Subject: Finley Battery Energy Storage System (BESS) (SSD-72430958)

ATTACHMENT A – RD Assessment Summary for Finley Battery Energy Storage System (SSD-72430958)

ATTACHMENT B – Detailed advice for Finley Battery Energy Storage System (SSD-72430958)

Figure 35:
Post-Development Scenario – Maximum
Flood Depth, 1% AEP Event

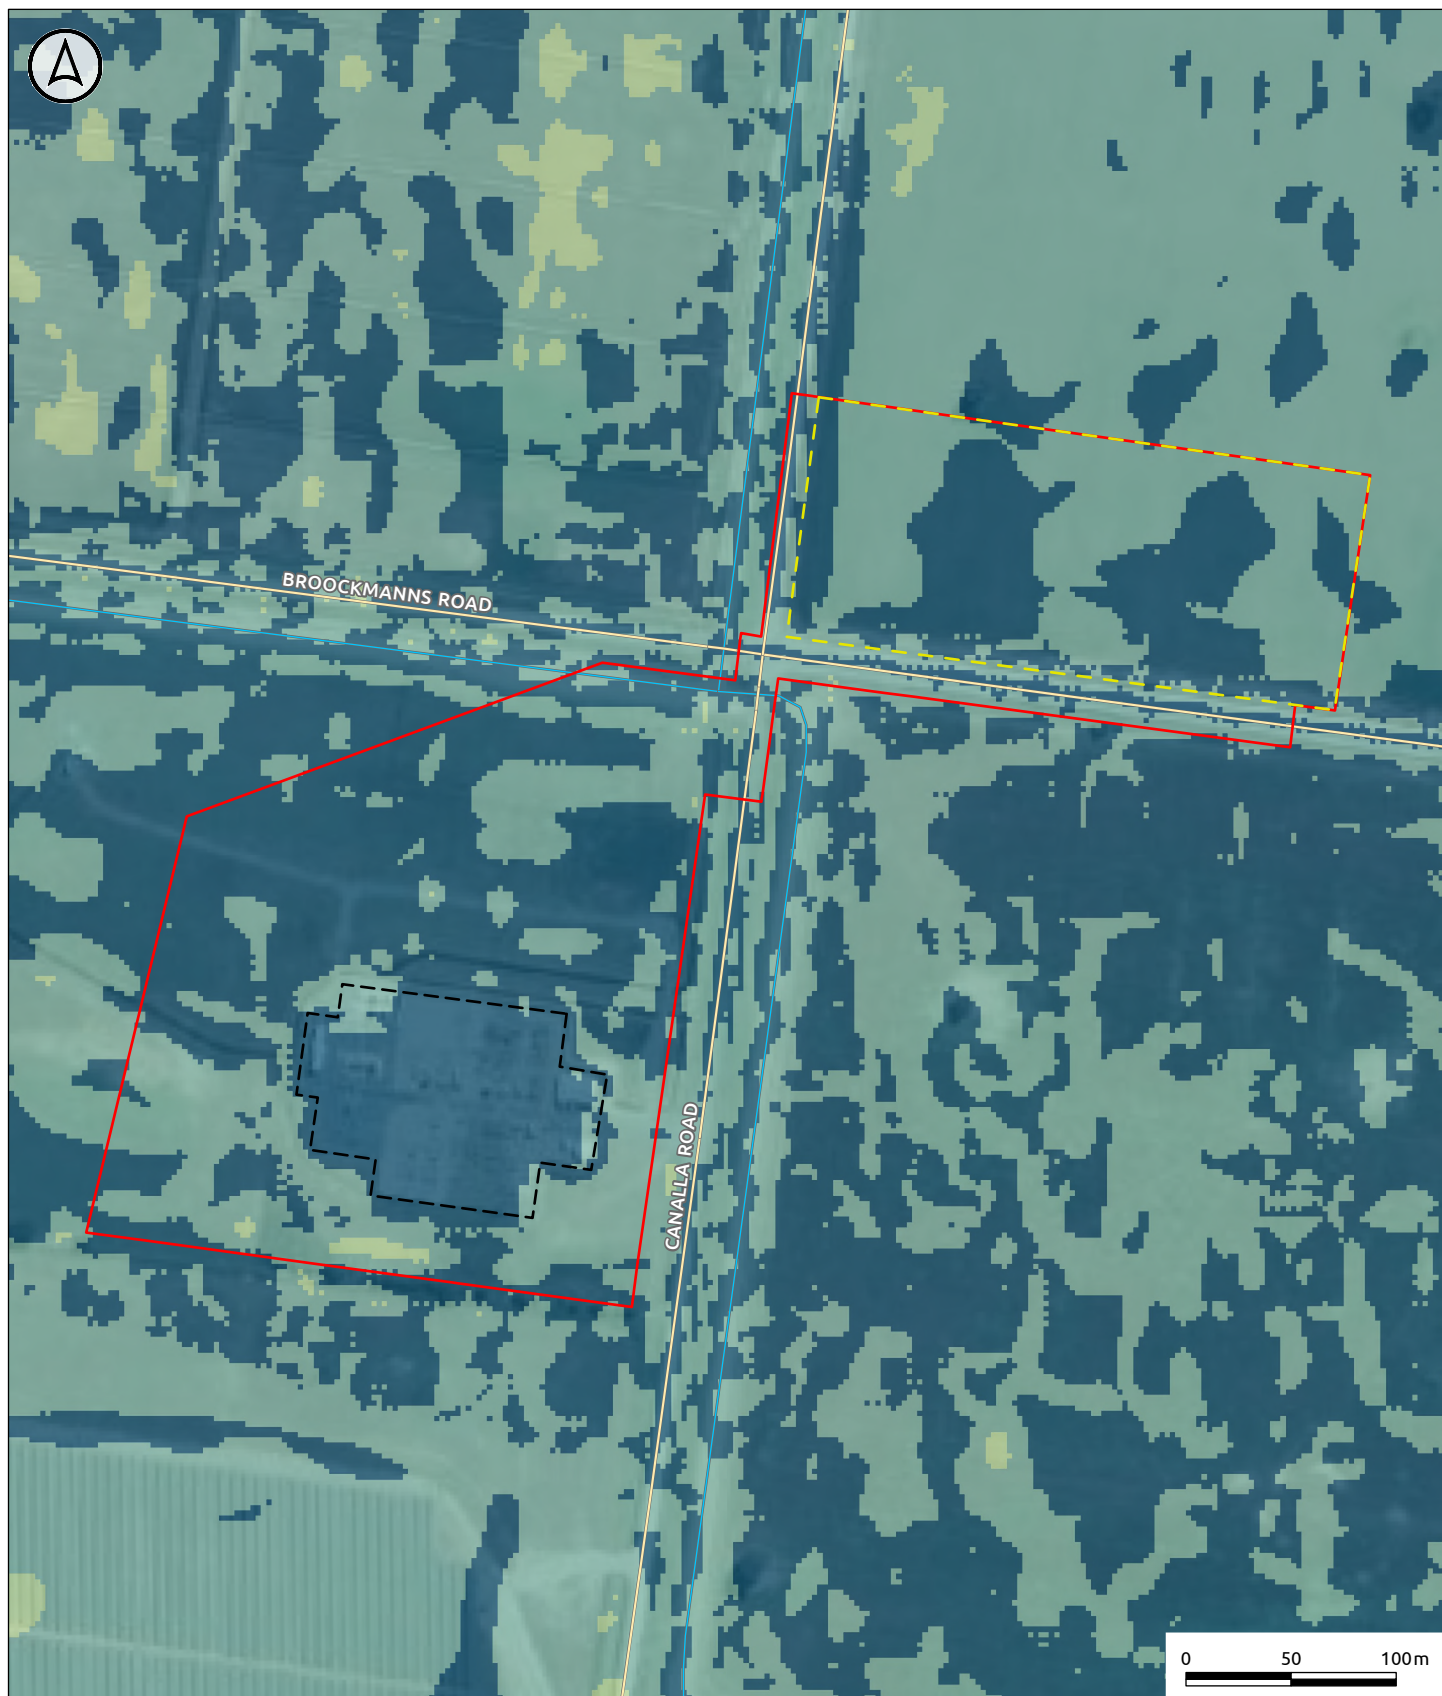
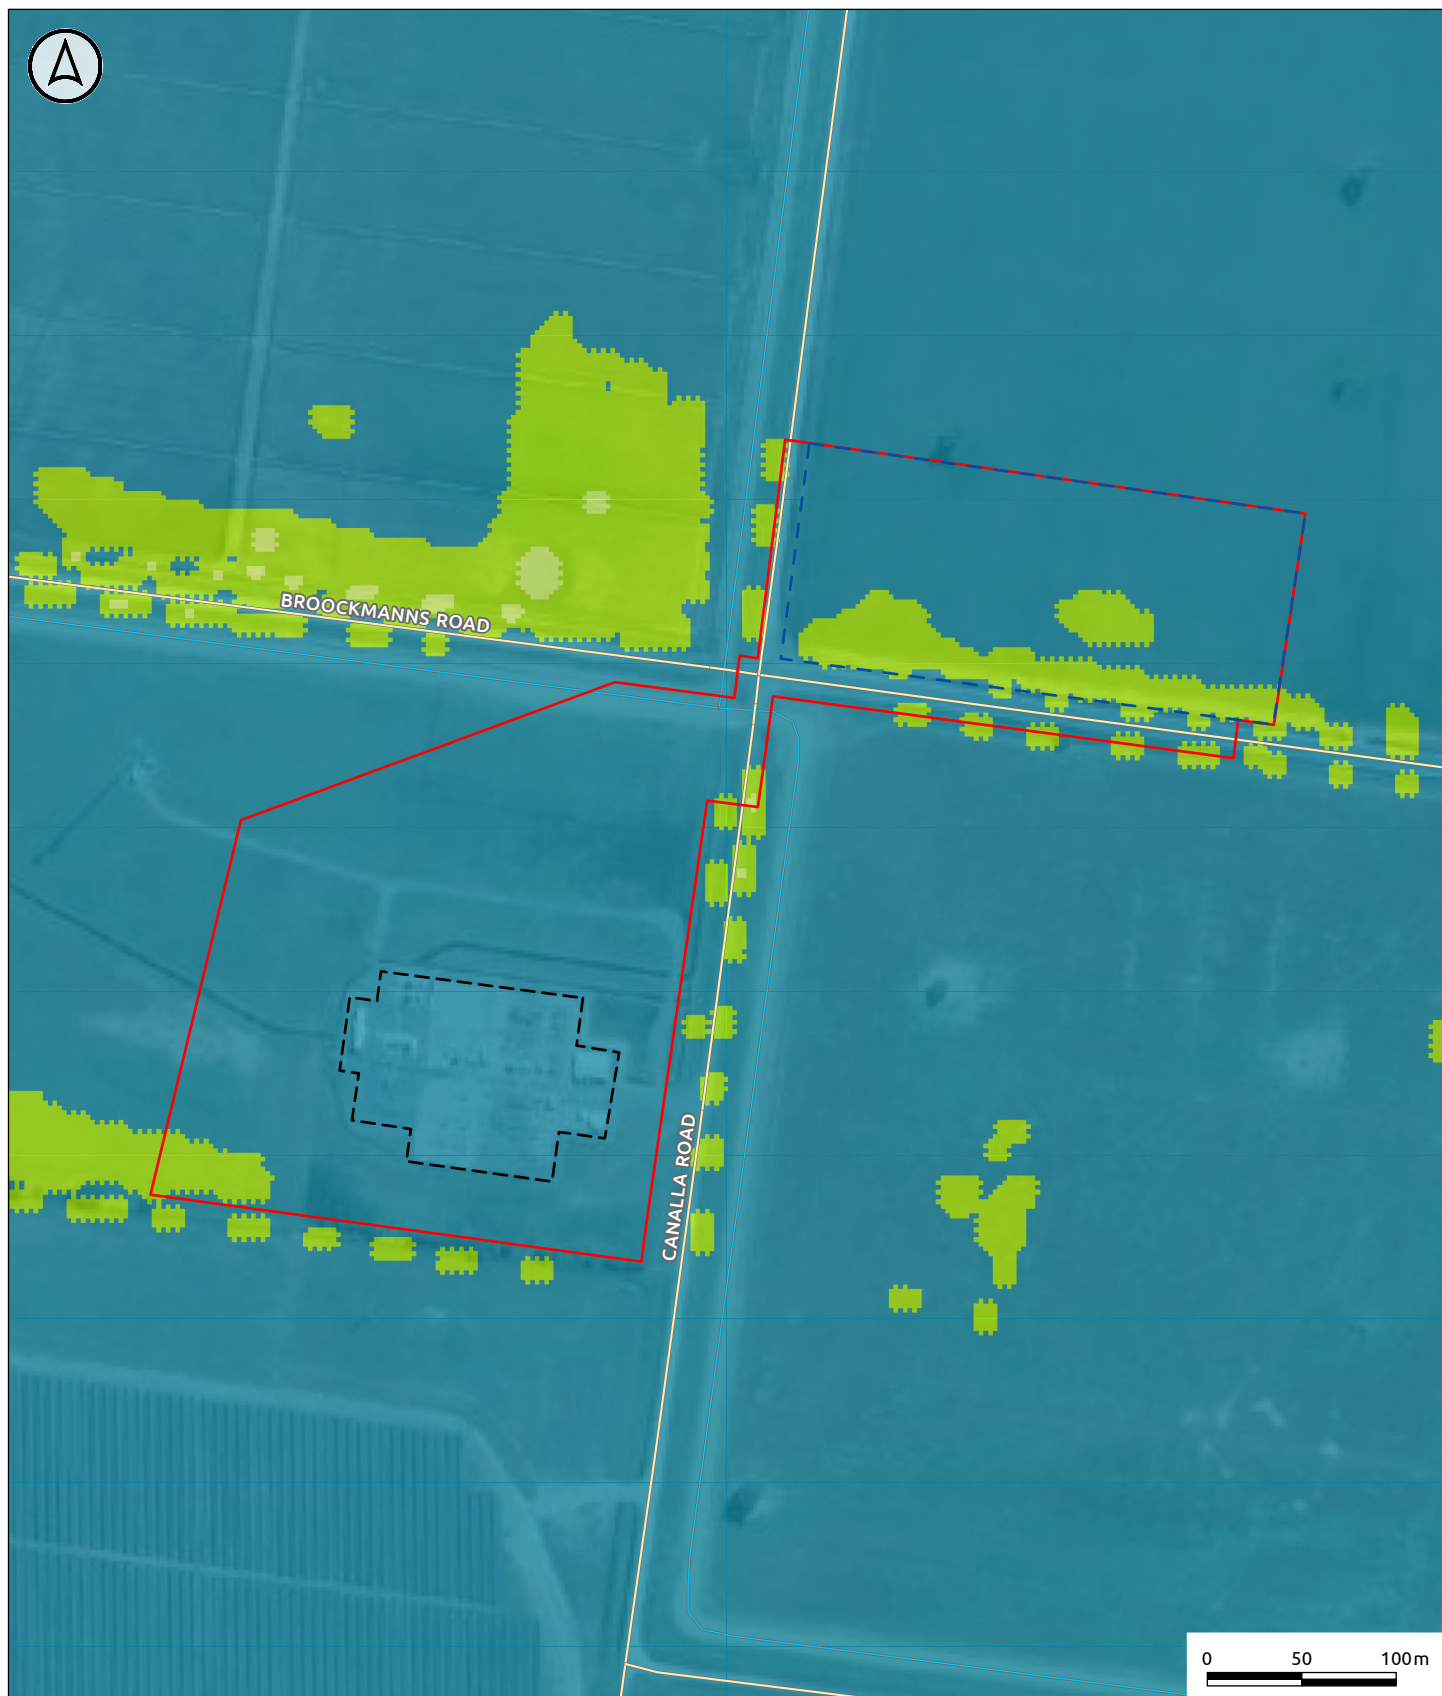
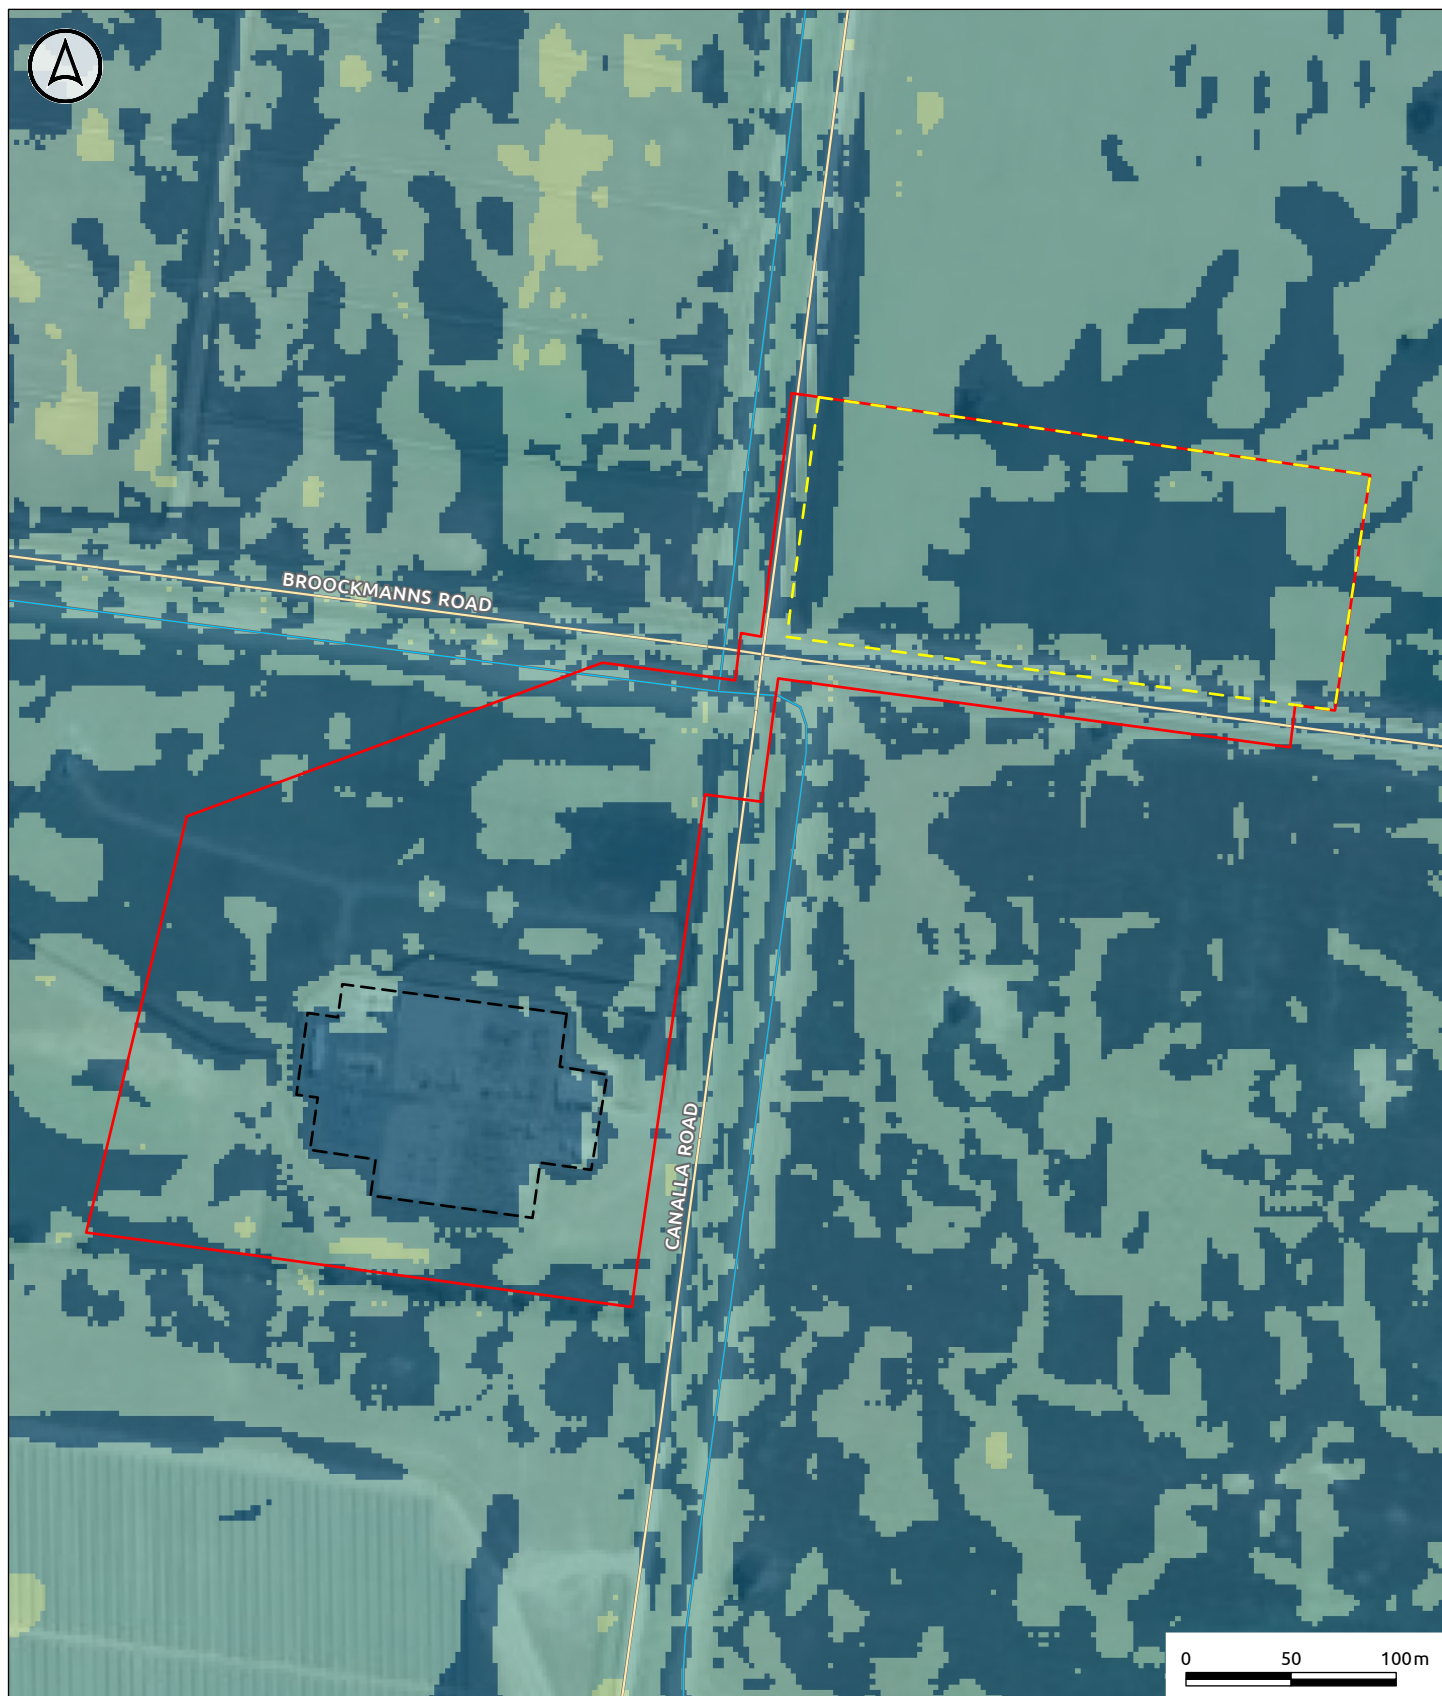
- 1.2. Utilise the 0.5% and 0.2% AEP events as proxies for assessing the impact of climate change.
2. The WIA needs to assess whether there will be detrimental increases in flood affectation of other properties and/or assets off-site

The WIA provides an assessment of the proposed site conditions on the 1% AEP flood event. The WIA includes afflux mapping which indicates that there is a slight (0.04 m) increase in flood levels to the northeast in the post-development scenario. RD notes that a dwelling and ancillary infrastructure is in proximity to the demonstrated afflux. The proponent should conduct further assessment, including assessing the additional design flood events, to accurately define the off-site impacts. Any identified detrimental increases in flood affectation to off-site properties and/or assets must be adequately mitigated.

- 2.1. Conduct further assessment to adequately define any detrimental increases in flood affectation of off-site properties and/or assets.
- 2.2. Where detrimental increases in flood affectation are identified the proponent should describe how the risk will be mitigated.
